# SETTLERS RANCH

## Filing No. 2C

# Construction Drawings

## El Paso County, Colorado

SHEET: PH1C

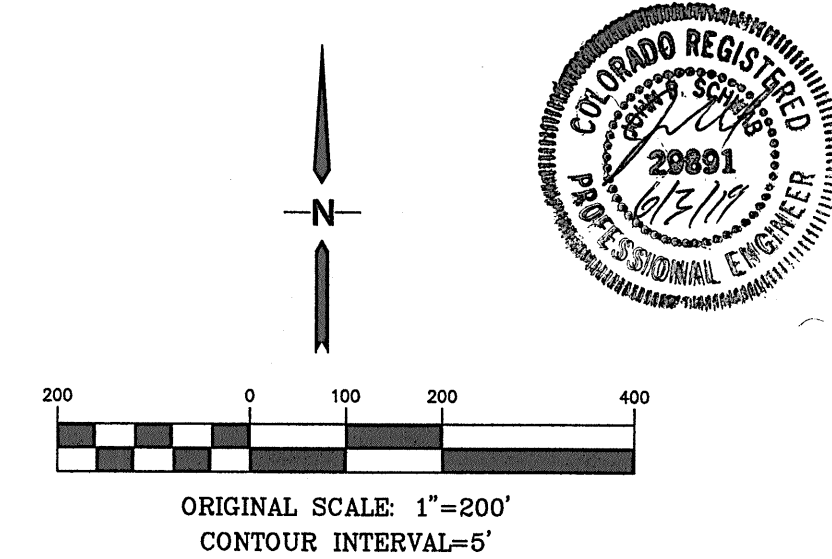
Update any reference from Development Services Department (DSD) to Planning and Community Development (PCD)

SHEET: C1.02C

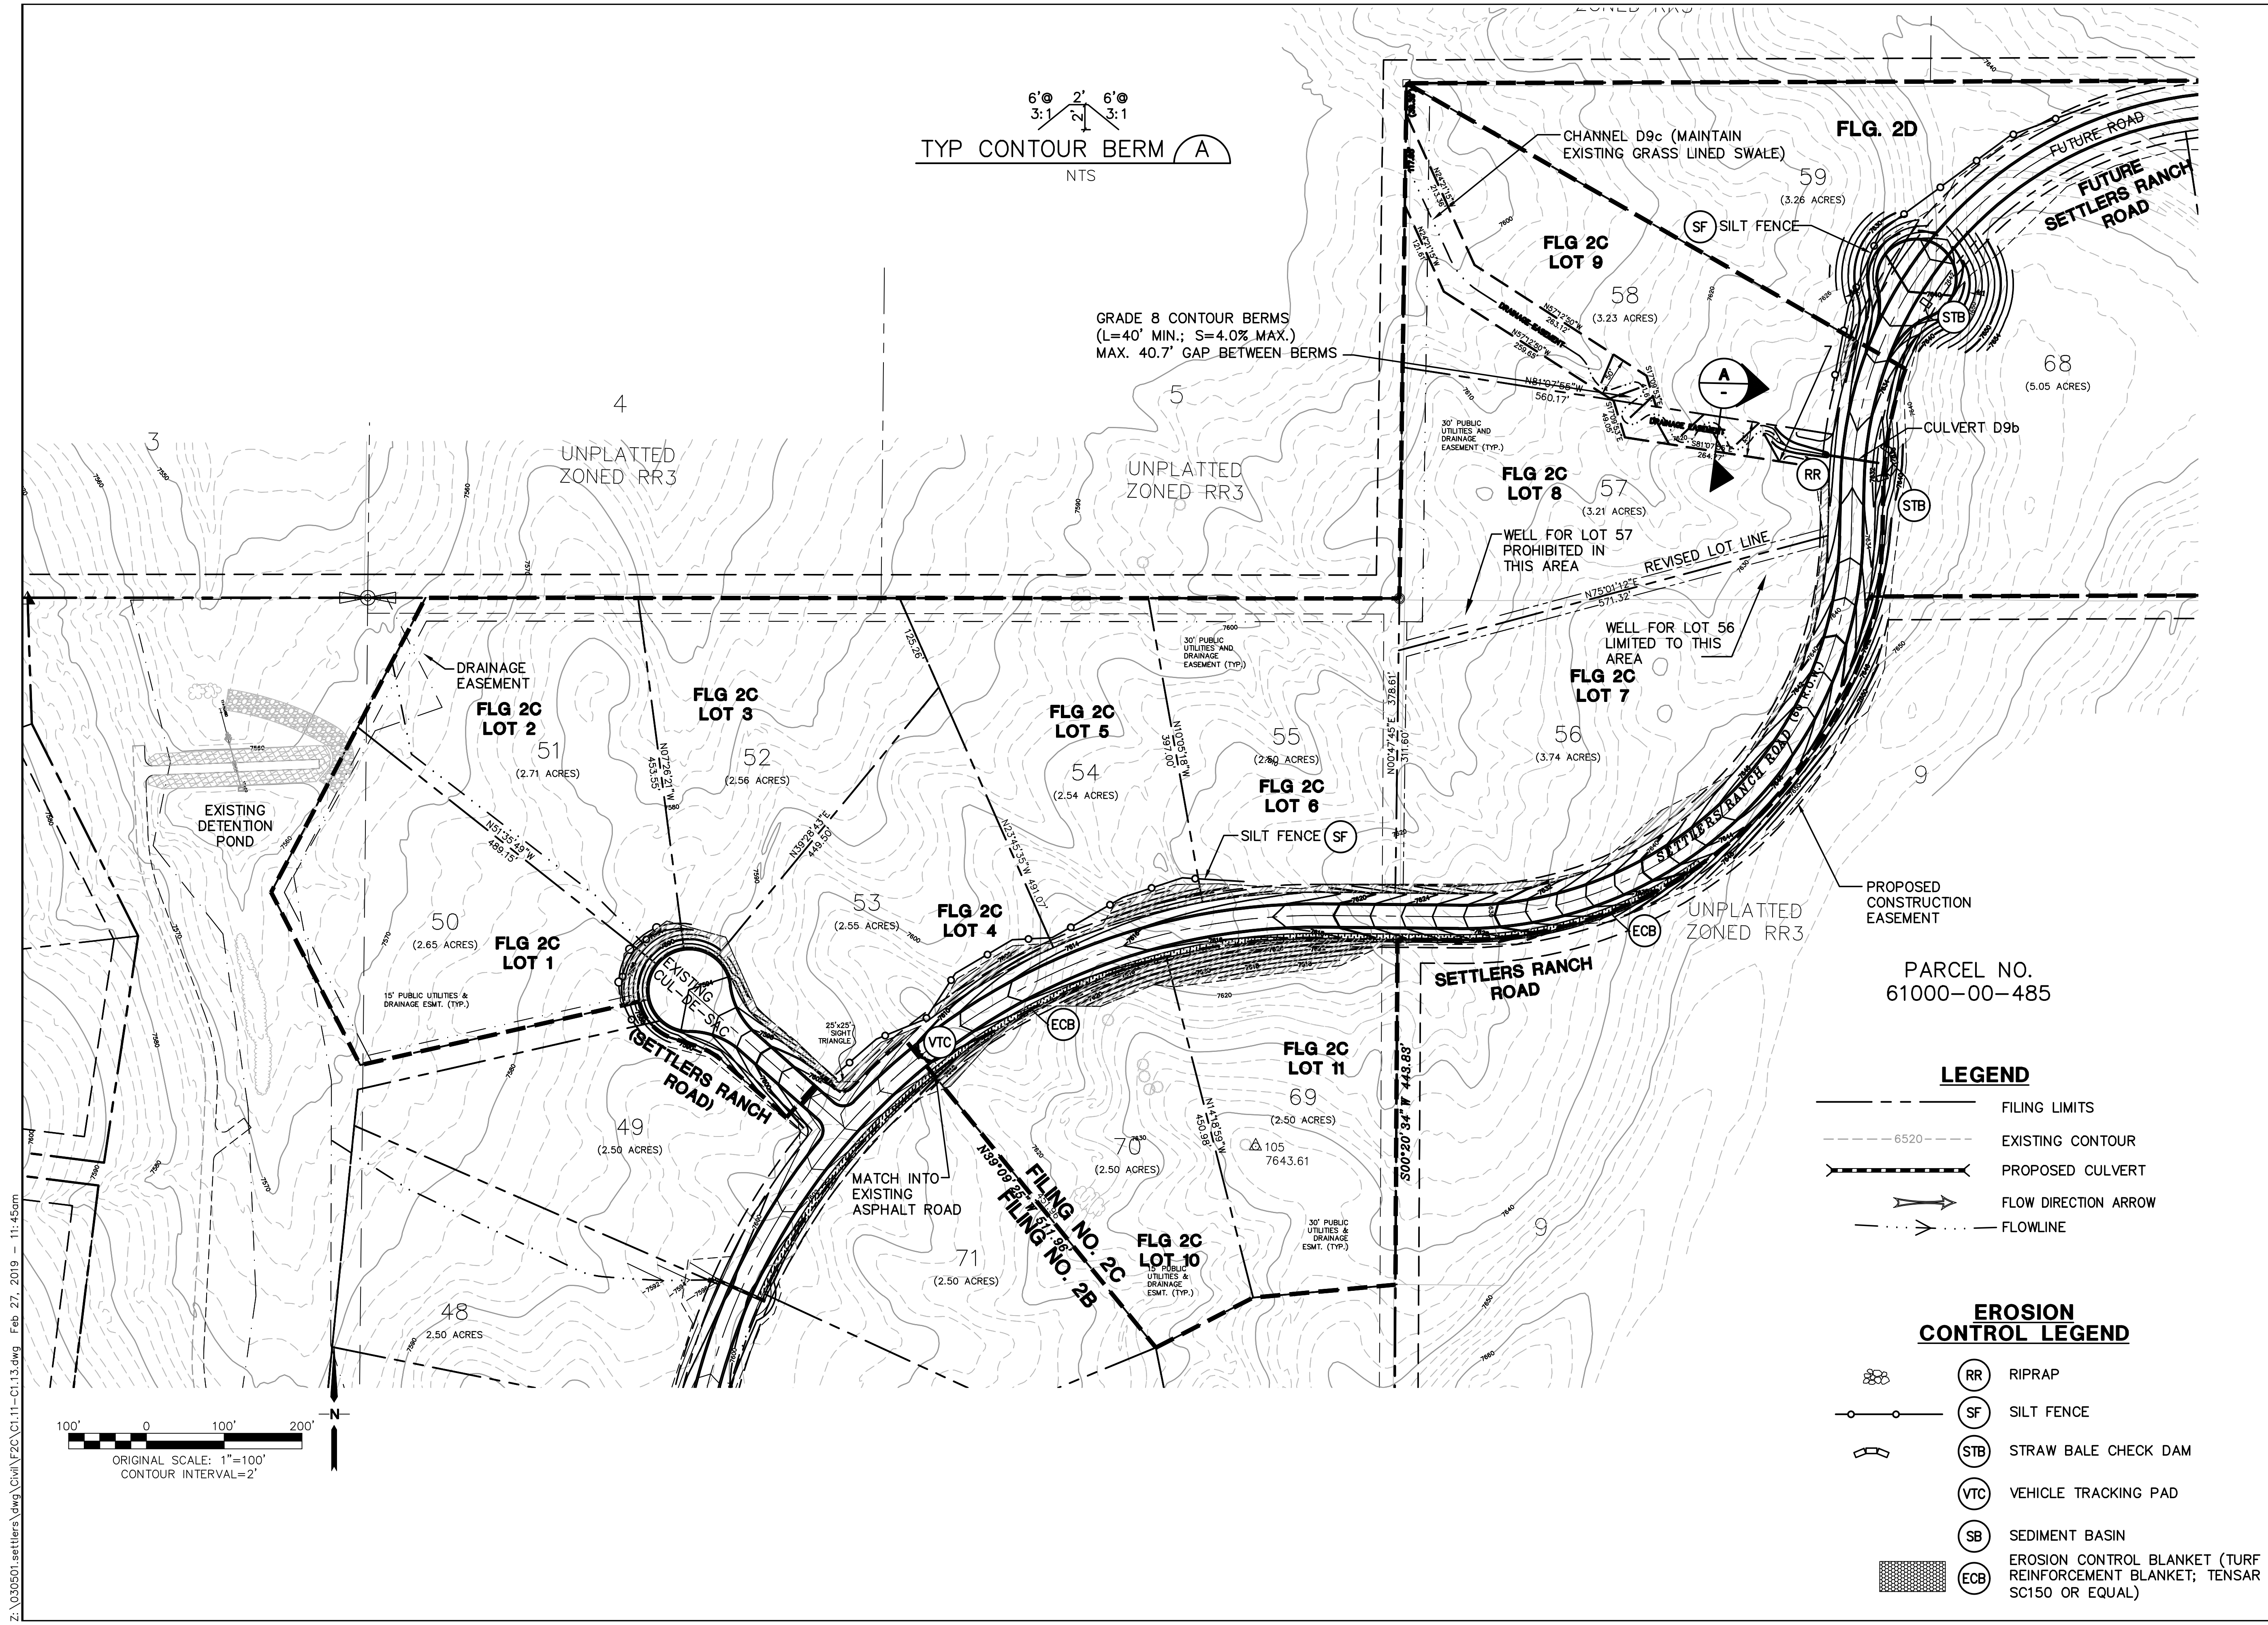
remove the word 'preliminary'
